From: alan.story@hertfordshire.gov.uk
To: [Planning](#)
Subject: Planning application 6/2019/0217/MAJ - Northaw House
Date: 18 April 2019 09:39:28

District ref: 6/2019/0217/MAJ

HCC ref: WH/54/2019

Conversion of Northaw House to form 11 apartments (including refurbishment of existing single caretaker's flat) and underground parking area, the ballroom wing to form 2 dwellings, the stable block to form 1 dwelling, refurbishment of existing dwelling at Oak Cottage, construction of 2 gate lodge dwellings, 3 dwellings within the walled garden, 7 dwellings within the settlement area, refurbishment of the walled garden, refurbishment of access routes and reinstatement of old route, provision of hard and soft landscaping, car parking and supporting infrastructure

Project Ref KMC-01	Rev 01
-----------------------	-----------

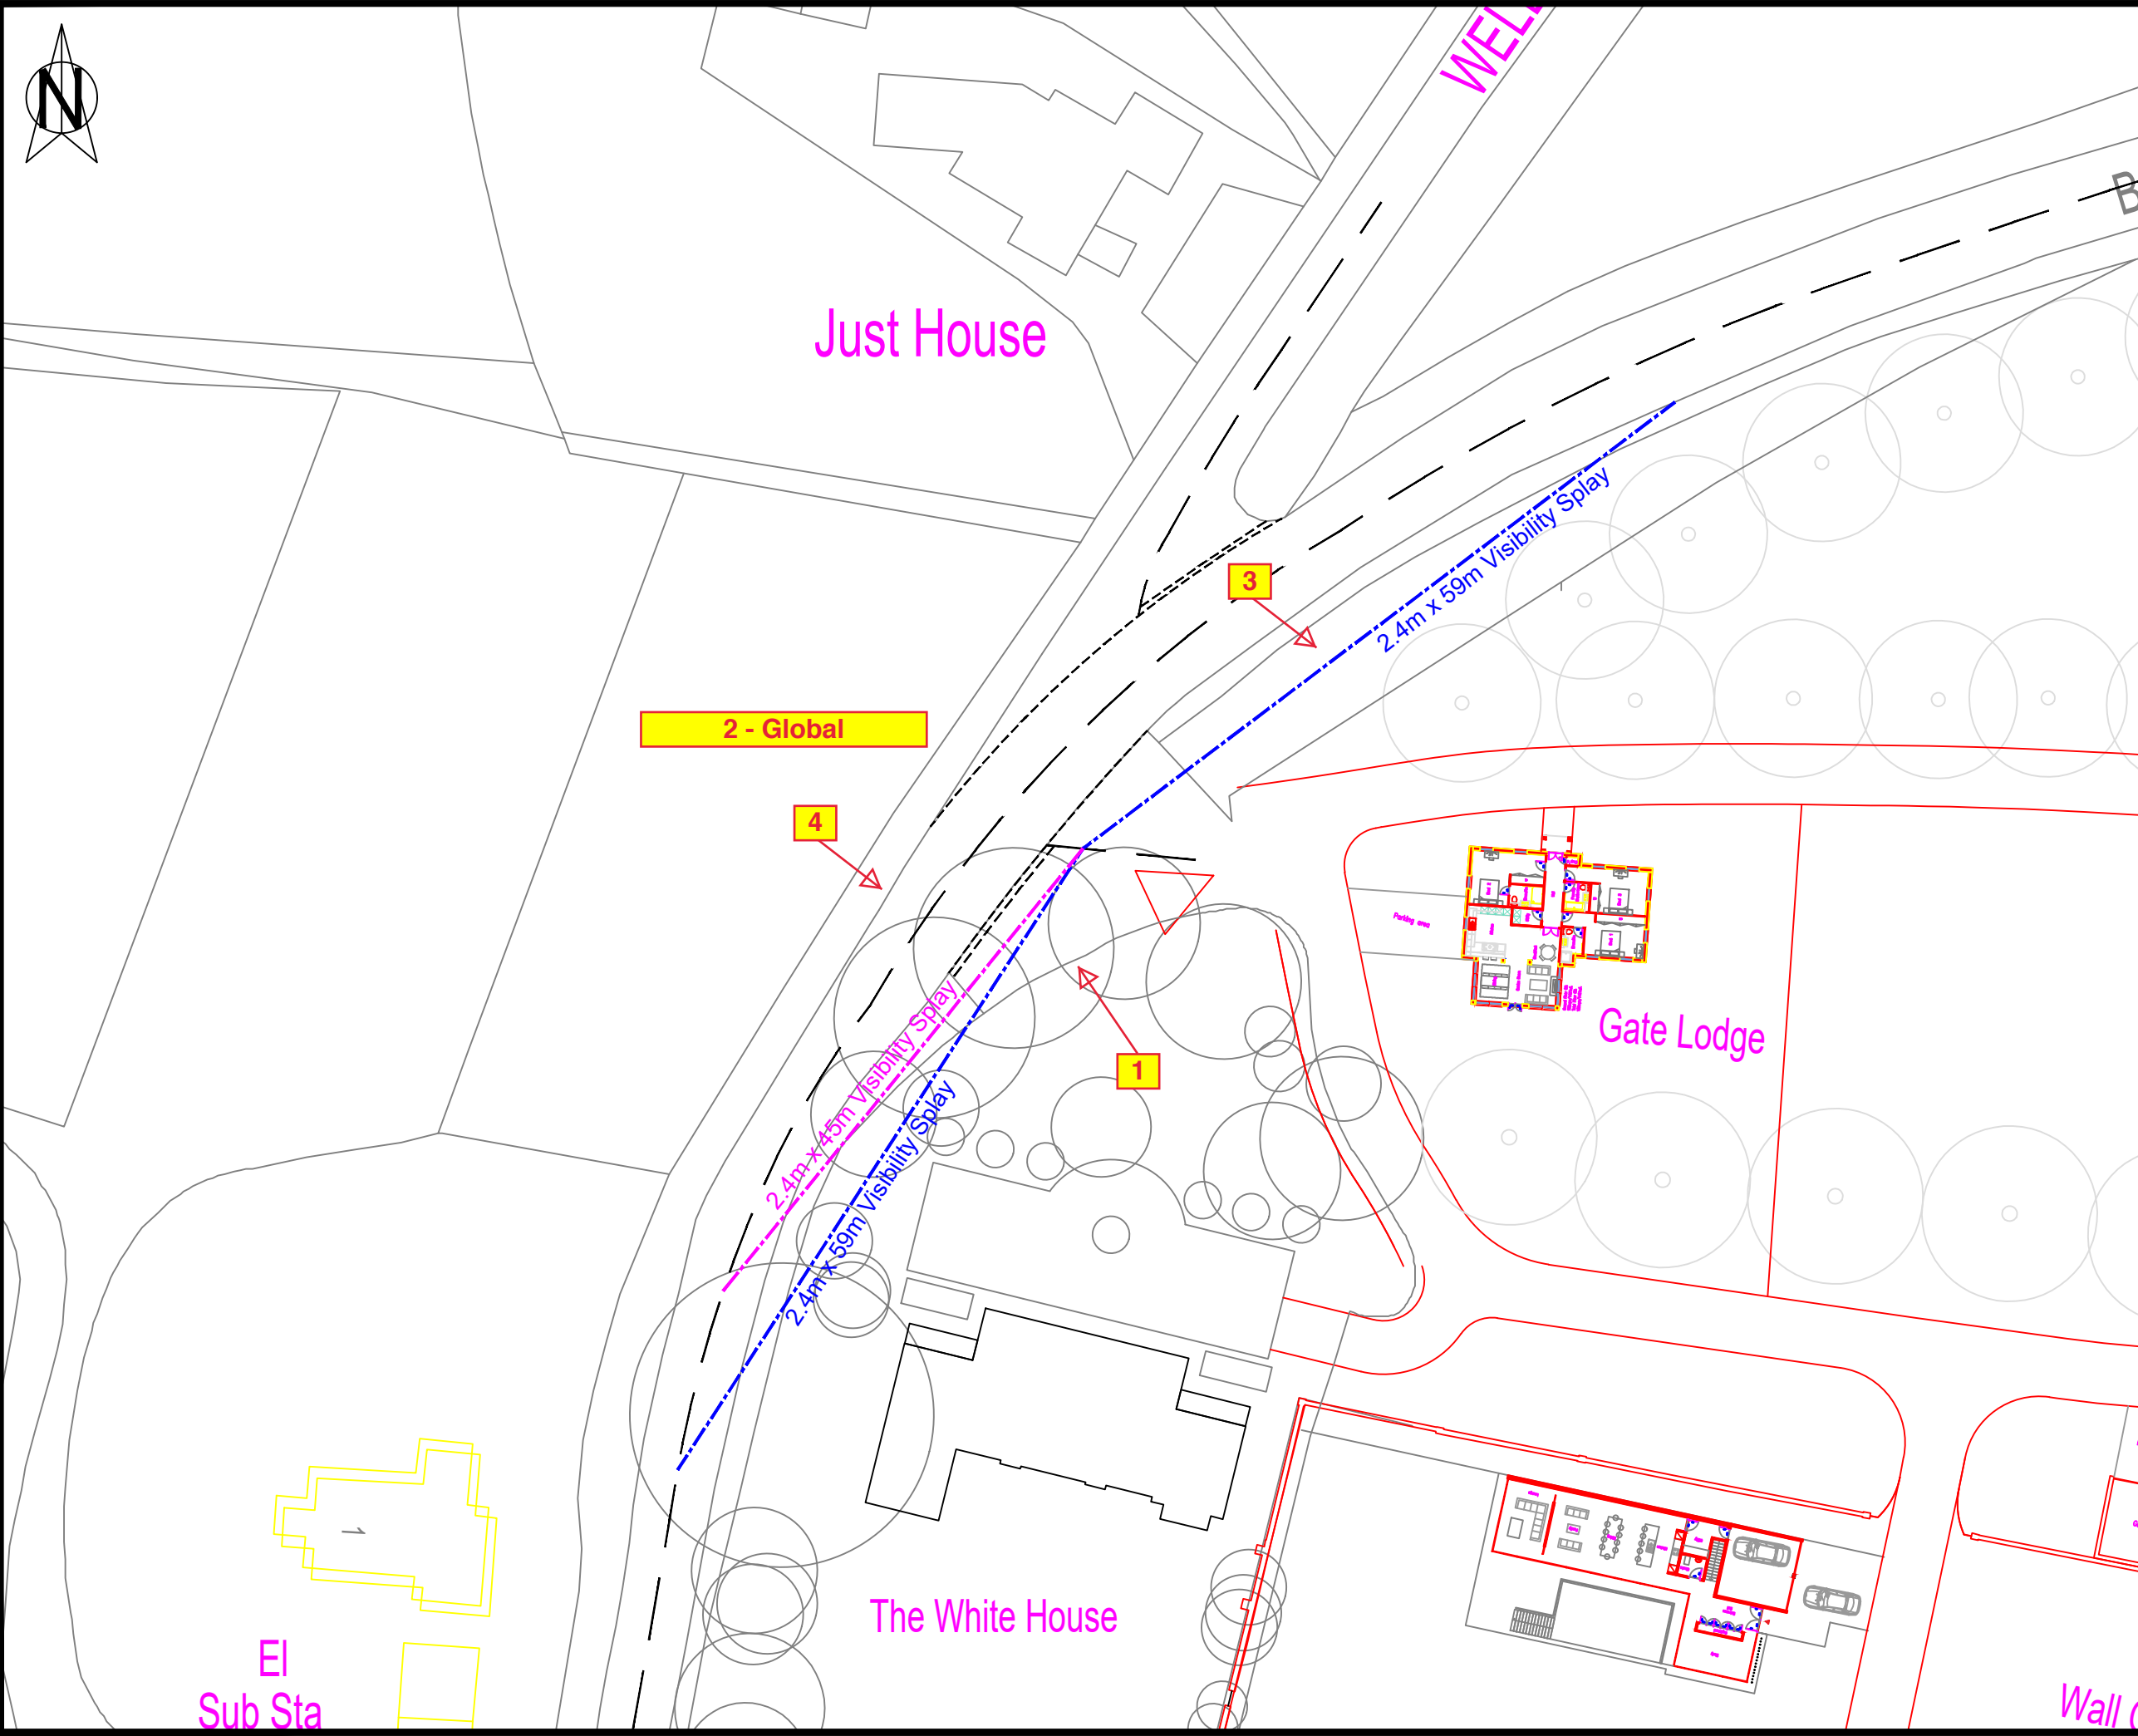
Visibility, from the western access, is assessed as deficient to MfS standards for a 40mph road, however the application is supported by speed survey data indicating that 85%ile speeds are measured at 35mph. It is therefore recognised that the western access, despite a number of minor improvements (junction radii / improved road marking / slow markings on approach to the bend) has visibility beneath that required. The use of MfS visibility splays is correct recognising that the County Council identifies within Roads in Hertfordshire: Highway Design Guide 3rd Edition Section 1: Policy Information and General Guidance Chapter 1 that MfS recommendations may be used on roads with 37.5 mph (60kph) or lower actual (85th percentile) speeds.

It is recognised that drawing KMC-01 rev 01 incorrectly identifies the visibility splay. Visibility splays, as directed by MfS are measured to the kerb face, whereas KMC-01 measures to centre line. At this point on Coopers Lane no physical measure prevents vehicles overtaking. Actual visibility would therefore be measured as 49m to kerb face, or 52m to a point that vehicles would be expected to be (MfS2).

3) Prior to the first occupation of the development hereby permitted a visibility splay shall be provided in full accordance with the details indicated on the approved plan number (KMC01 rev 01 and KMC02 Rev 01). The splay shall thereafter be maintained at all times free from any obstruction between 600mm and 2m above the level of the adjacent highway carriageway.

Drawing Ref KMC001 - 01 (Sheet 2 of 2)	Rev 02
---	-----------

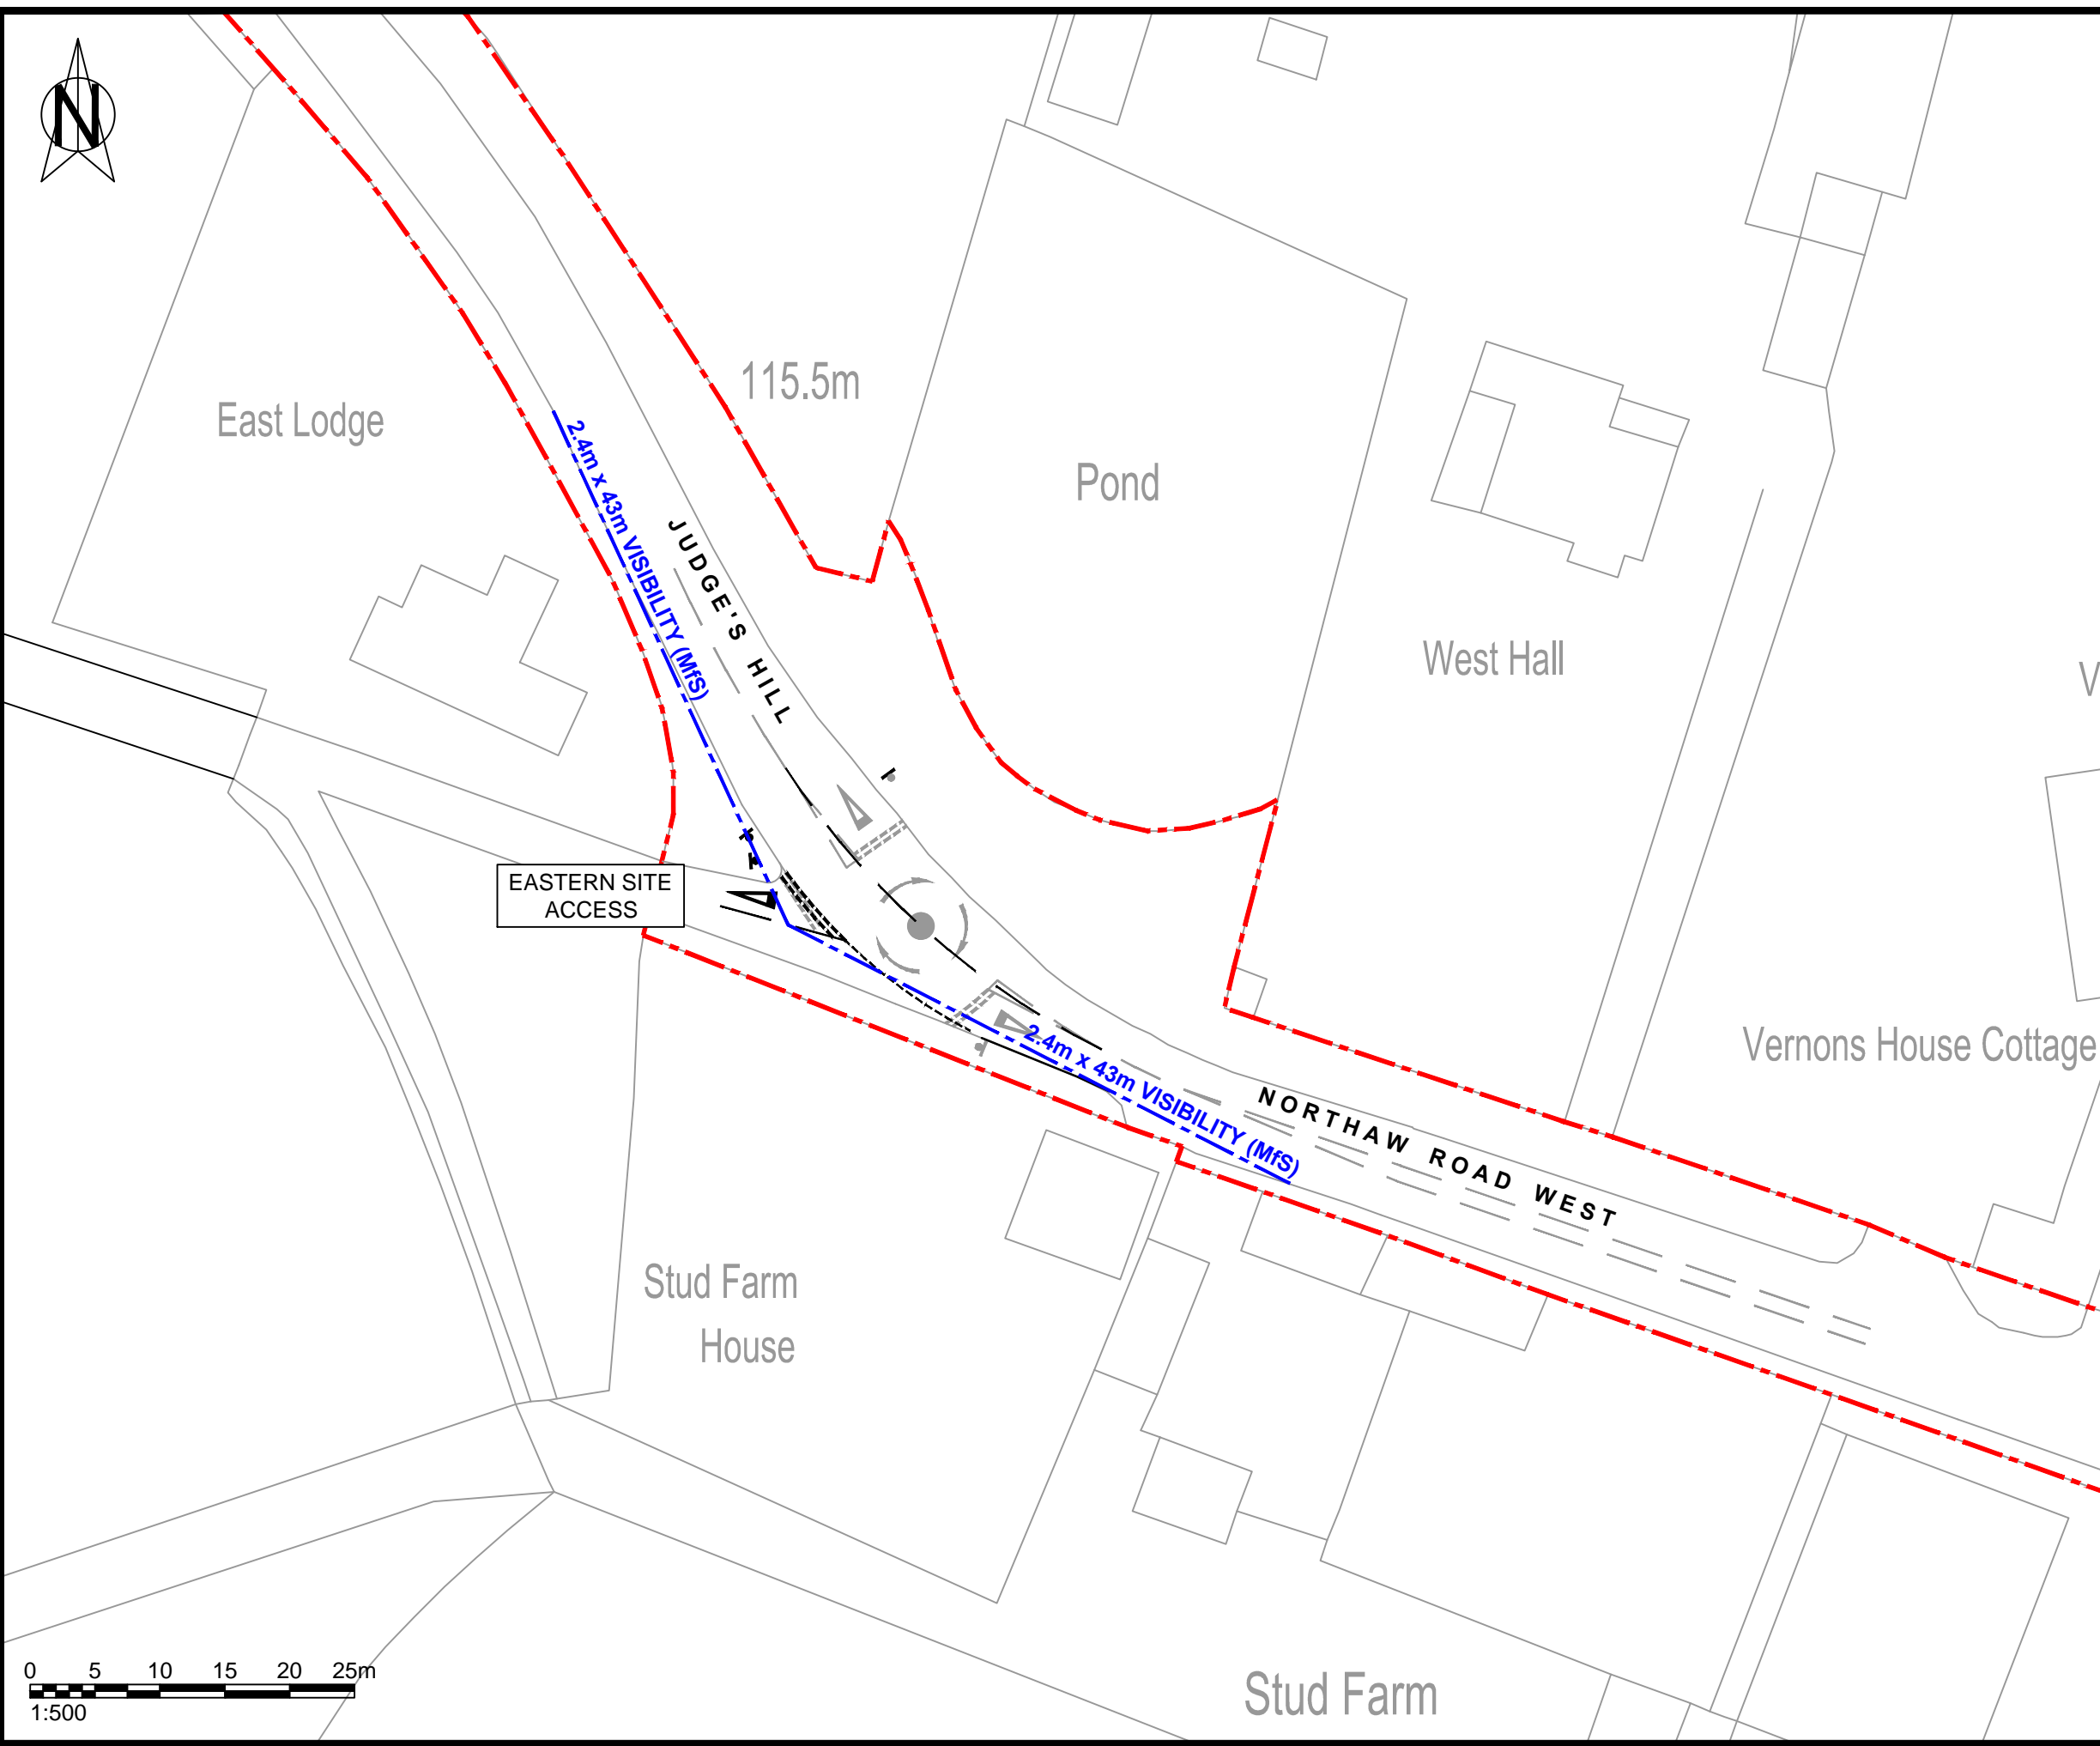
Visibility from the eastern access is sufficient for the posted vehicle speeds (43m SSD adjusted in both directions). The proposed junction changes (removal of miniroundabout and replacement with priority junction) is deemed acceptable to the Highway Authority. Such improvements also include hardening of carriageway edge for improved definition, and replacement signage (to TSRGD) for road humps, and associated lining.

Improvements to the Western Access are also found to be agreeable to the Highway Authority. Access width is reduced to encourage slower vehicle speeds into the site, whilst simultaneously reducing the distance that pedestrians are within a point of conflict with vehicles. Lining on highway shall be refreshed (slow markings / centre line).

As identified within the safety audit, there is no history of accidents at this location associated with the use of the access and as accepted above, the level of trips generated by the proposed residential development is significant reduced to that which may reasonably be generated by the extant use on the site. Opportunities exist to ensure that the visibility splay as shown on drawing KMC01-01 which appears to require treatment to existing boundary shall be maintained in future (conditioned).

i) Concurrent with the improvements to points of access (as condition 2 below), all off-site highway works shown on drawing KMC001-1 Rev 2 shall be delivered to the satisfaction of the Highway Authority, and shall also include improvements to NE bound and SW bound bus stops local to the site to provide Kassel kerbing. Reason: To ensure that sustainable travel options associated with the development are promoted and maximised to be in accordance with Policies 1, 3 and 6 of Hertfordshire's Local Transport Plan (adopted 2018).

2) Prior to the first occupation hereby permitted vehicular accesses (indicated for improvement on drawing number (KMC001-1 rev 2) shall be reduced in width and provided with kerb radii as shown. Prior to use arrangements shall be made for surface water drainage to be intercepted and disposed of separately so that it does not discharge from or onto the highway carriageway.
